From:
To: [DCAdmin](#)
Cc:
Subject: Consultation Response 2021/62/91700/W MAC's Truck Sales Ltd, Crosland Road, Lindley, Huddersfield, HD3 3ZA
Date: 01 December 2021 17:33:14
Attachments: [image001.png](#)
[image002.png](#)
[image003.png](#)

**2021/62/91700/W Erection of extension to vehicle workshop, engineering operations to excavate and regrade land, formation of extensions to car park and external yard areas, erection of 2.4m high security fencing, external lighting and temporary construction access
MAC's Truck Sales Ltd, Crosland Road, Lindley, Huddersfield, HD3 3ZA**

Title: **Proposed Temporary Construction Access**

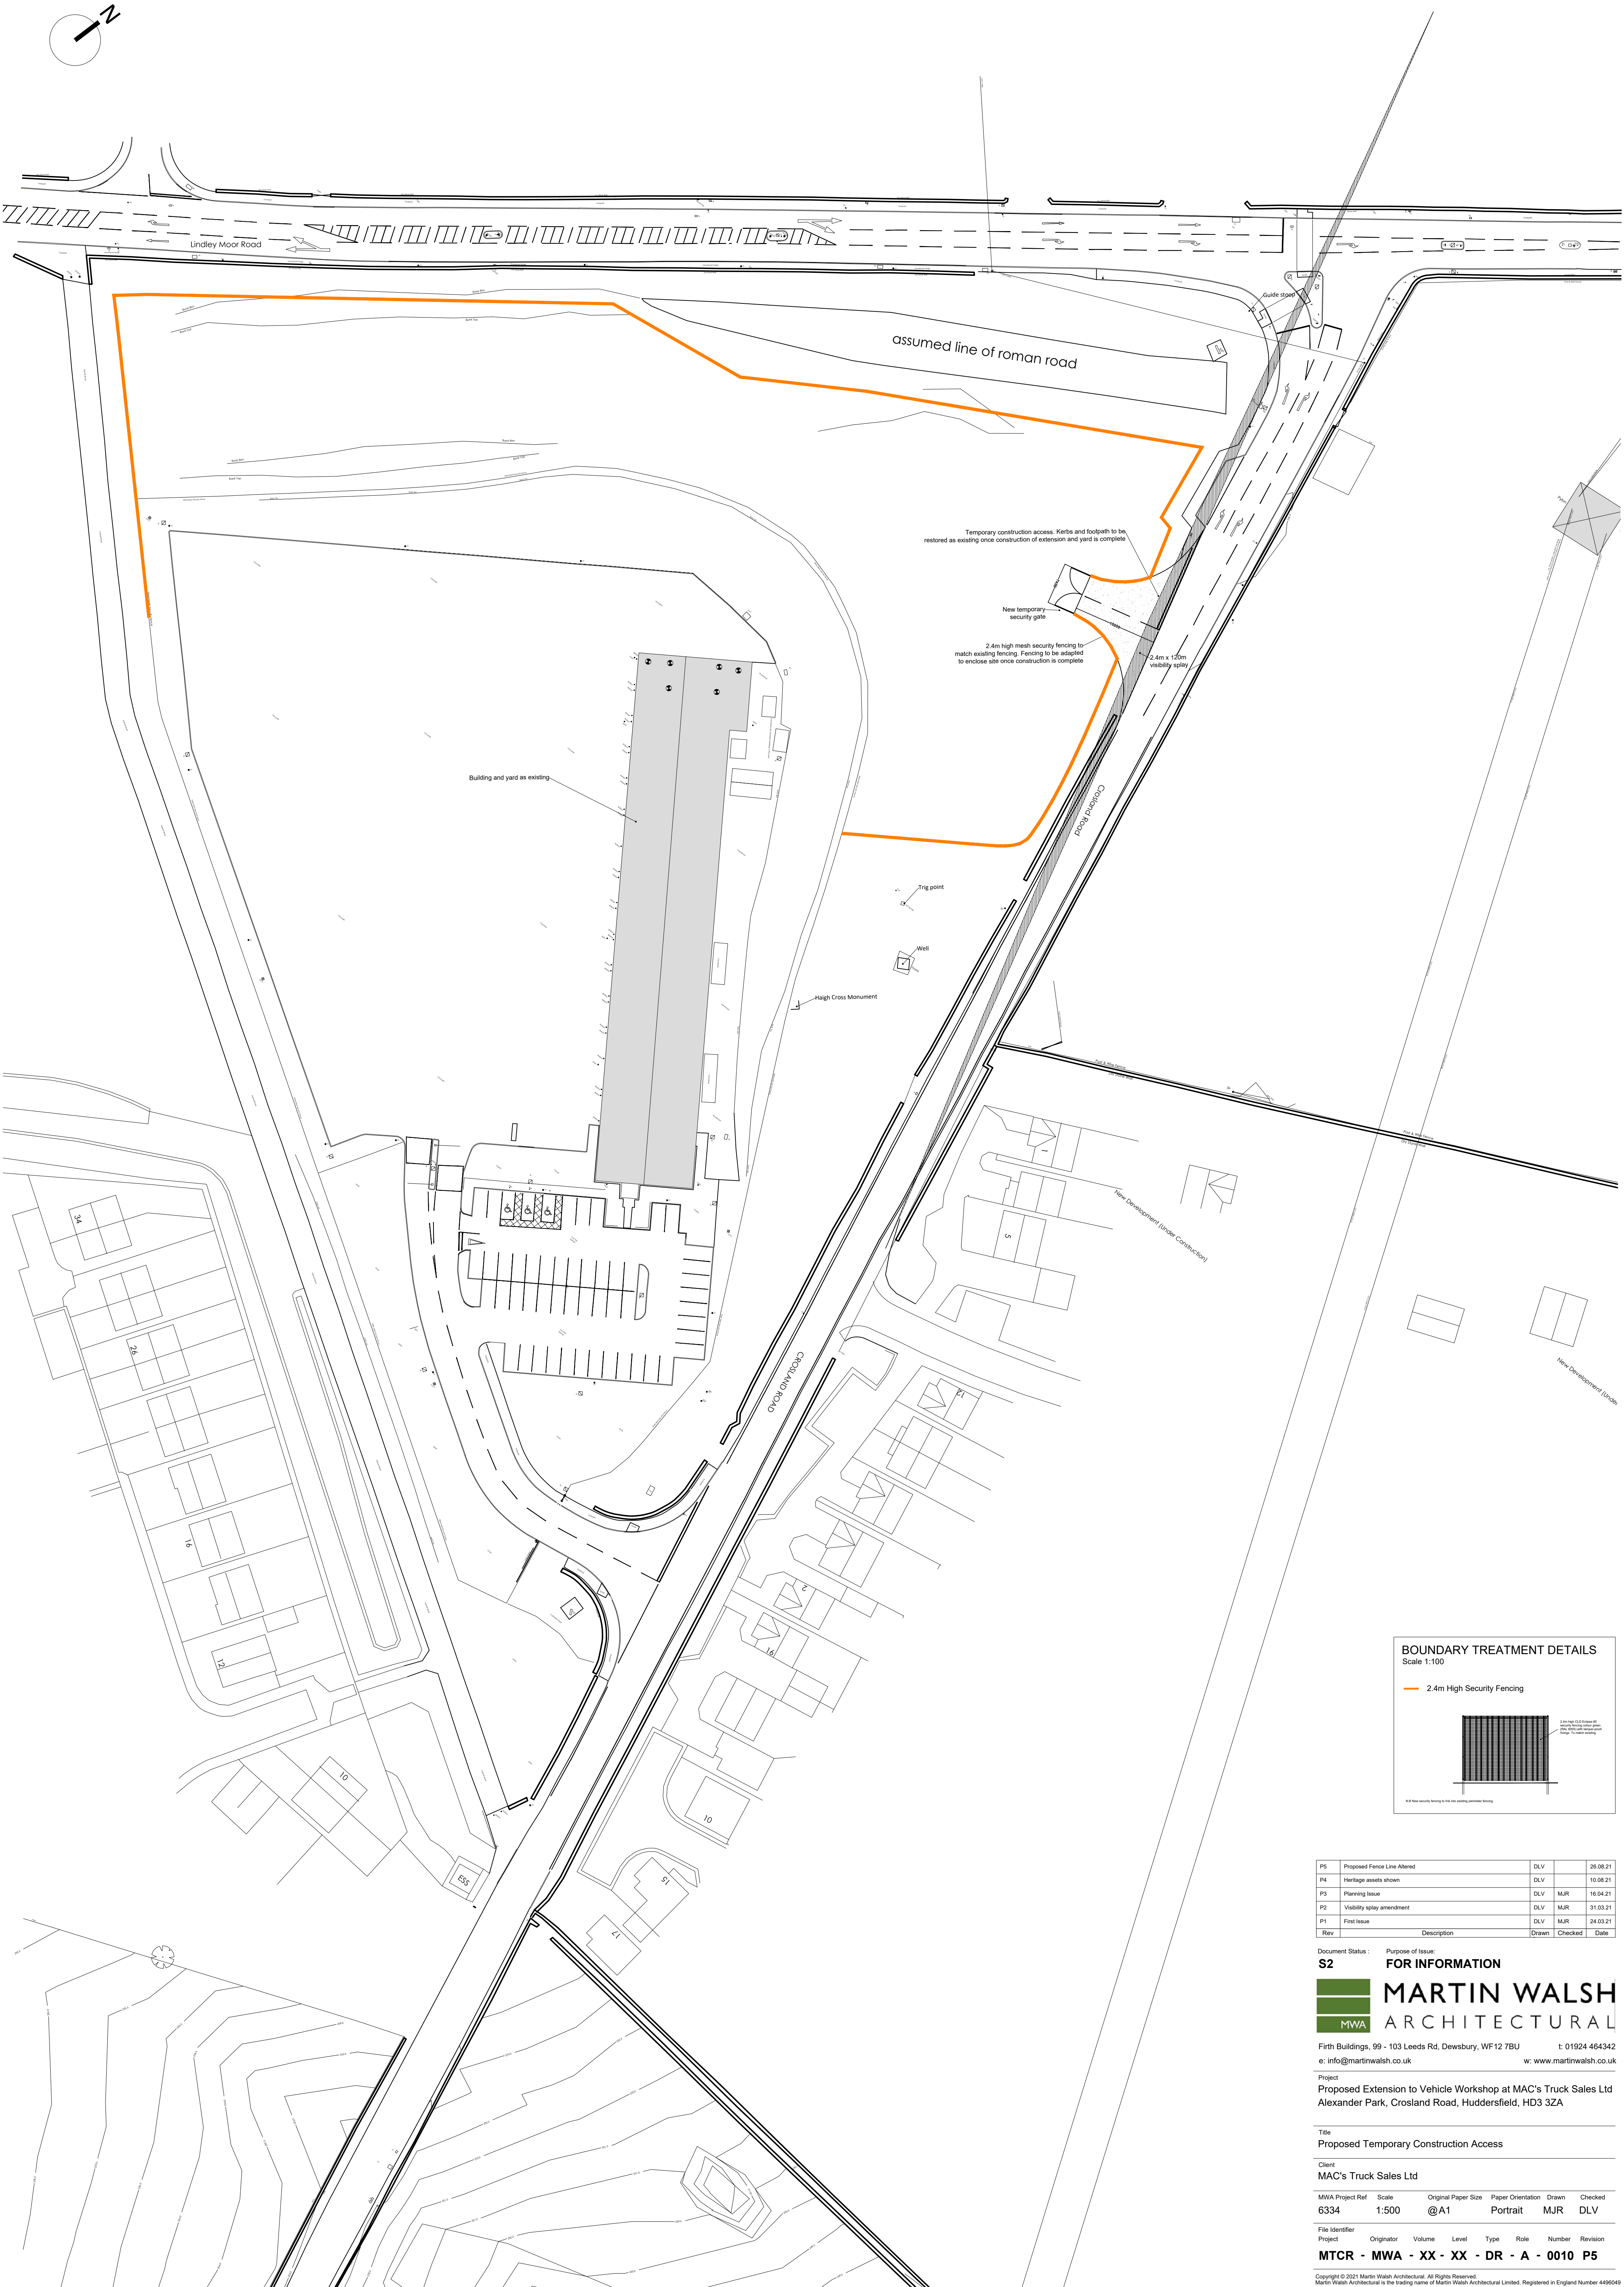
The Archaeological Assessment make reference to activities within the area of the Class 2 Area of Archaeological Importance which threaten the remaining intact portions of the Roman Road. These are to place topsoil stripped from new car parking within the area of the Roman road, abstract page 3 and to "... establish temporary construction access through this area." section 5 page 21.

Such casual use of a regionally significant archaeological site is not justified and should not be permitted unless an adequate case and appropriate archaeological justification for these activities is made and a clear plan presented. Dumping of modern soil should not be permitted on the line of the Roman road nor in such a way as to obscure or conceal it. If, ultimately, consent for access and dumping of soil is given then there is a potential need for a programme of archaeological observation and recording during this activity.

In order to safeguard the remains of the Roman road from inadvertent damage during construction the most sensitive area should be protected by temporary fencing and this protection should be made a condition of any planning consent awarded by Kirklees council. Such a condition was implemented on consent 2014/93136 and is given below.

To securely fence the extent of the Roman road:

"No development shall take place until fencing has been erected, of a type and in a manner to be agreed in writing with the local planning authority, about the area of archaeological sensitivity confirmed by archaeological survey and no works shall take place within the area inside the fence without the consent, in writing, of the planning authority. The West Yorkshire Archaeology Advisory service should be informed in writing when the fence has been erected."
